**Application** H06-1292-25  
**Location** Land at Green Lane Holbech St Johns Spalding  
**Proposal** Erection of Agricultural Dwelling - outline approval H06-0101-24

**Name** National Grid Electricity Distribution  
**Address** formerly Western Power Distribution

Site Plan
Scale: 1:200

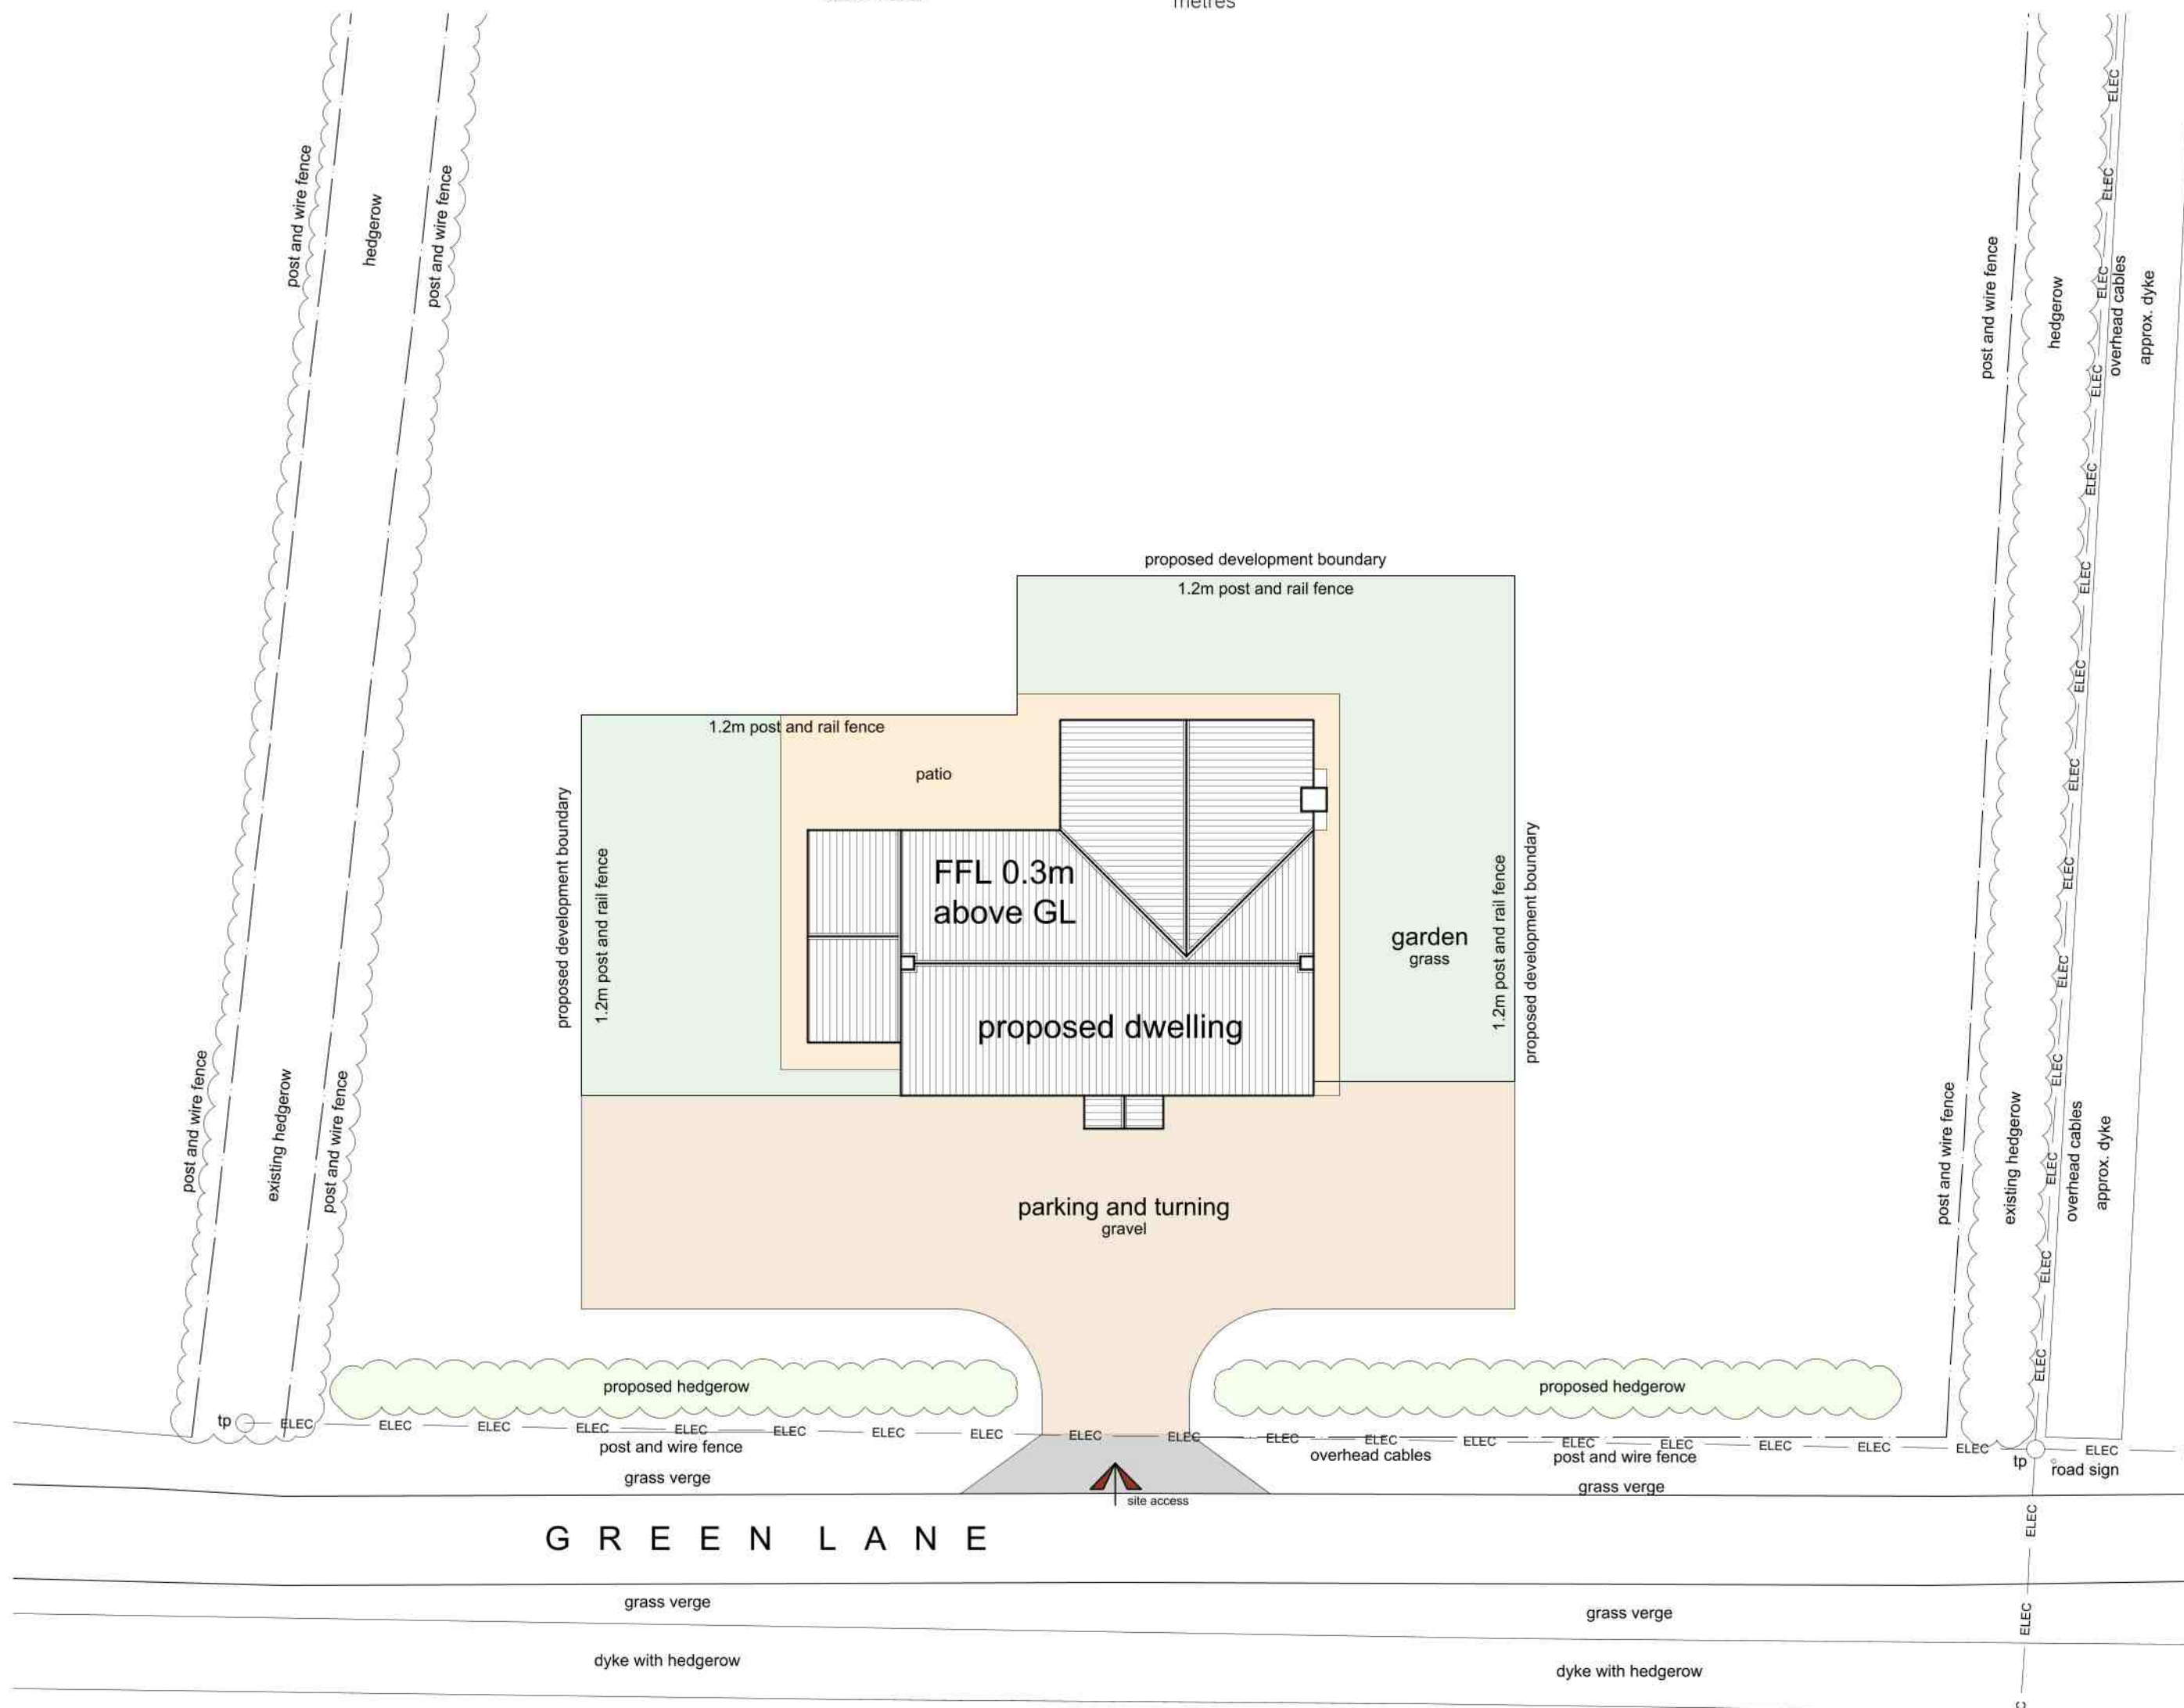
Please note the 11kv OH cable across the front entrance can not be shrouded during the development.
